Application No: FG/184/21/PL
Site Address: 1 Greenways Crescent Ferring BN12 5EF
Description of works: Erection of replacement dwelling and garage

Thank you for your internet representation made on 3rd December 2021 which has been recorded as an objection with the comments as follows:

Figure 1: Proposed site layout

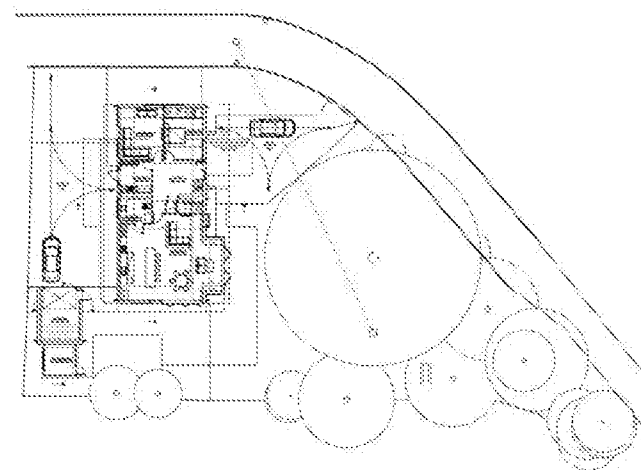
There will be an overall adverse, detrimental impact on the road as the development proposal puts the property beyond the existing boundary, it is totally out of character with the rest of the properties because it is closer to the narrow main road and is overbearing with regard to our property and to the rest of the existing development.

It is not in keeping with the rest of the 9 existing properties in the road as these are all set back from the road with mature gardens in front of them, changing the character of the local area.

Figure 3: Existing and proposed west elevations

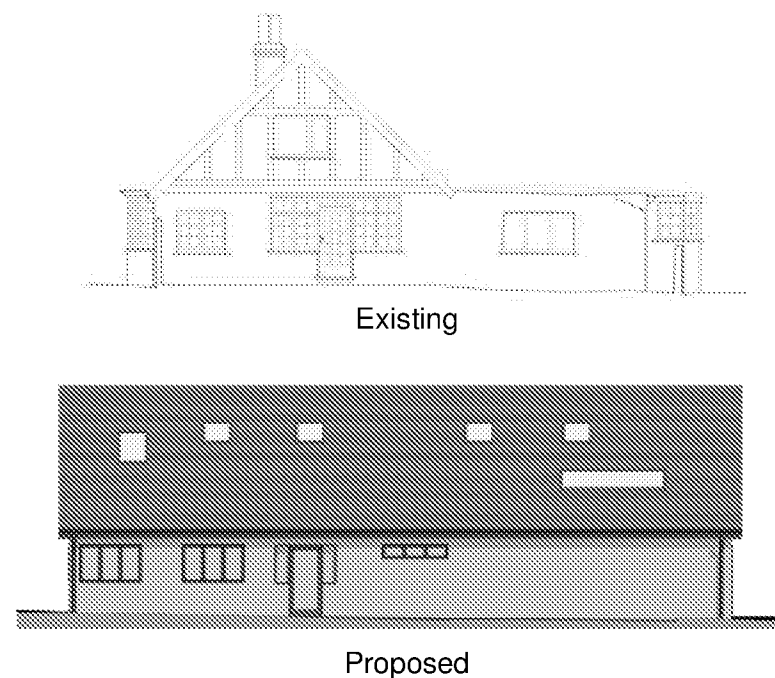
The proposed West facing windows again invade the privacy of a number of the existing developments from numbers 2-5.

Figure 4: Existing and proposed north elevations

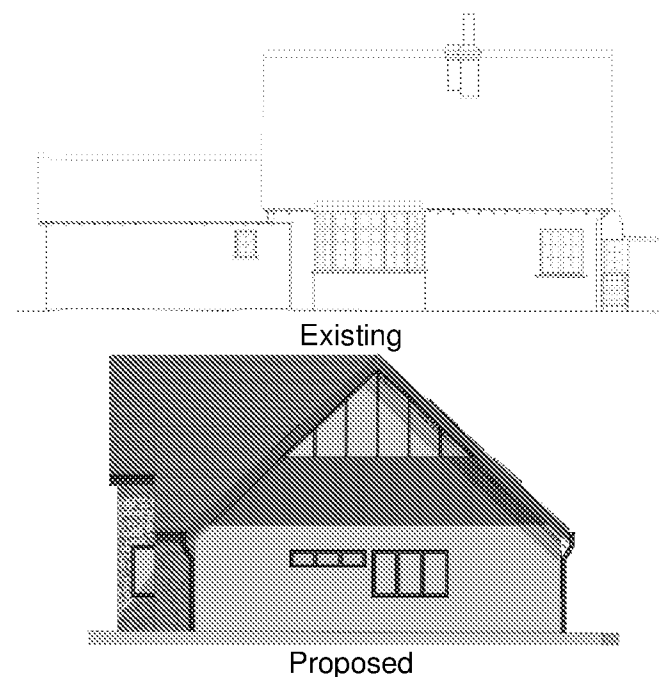
The upper gable window on the North side of the property will be very detrimental to our privacy with regard to the front bedroom and lounge. The North wing would also be overbearing in its close proximity to the front of our property.

Figure 7: Proposed garage

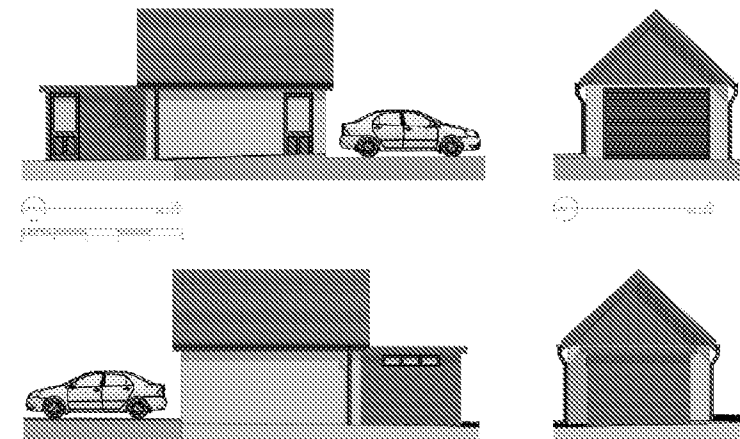
The pitched roof on the proposed garage again is not in keeping with the appeal of the area, again changing the character of the road.
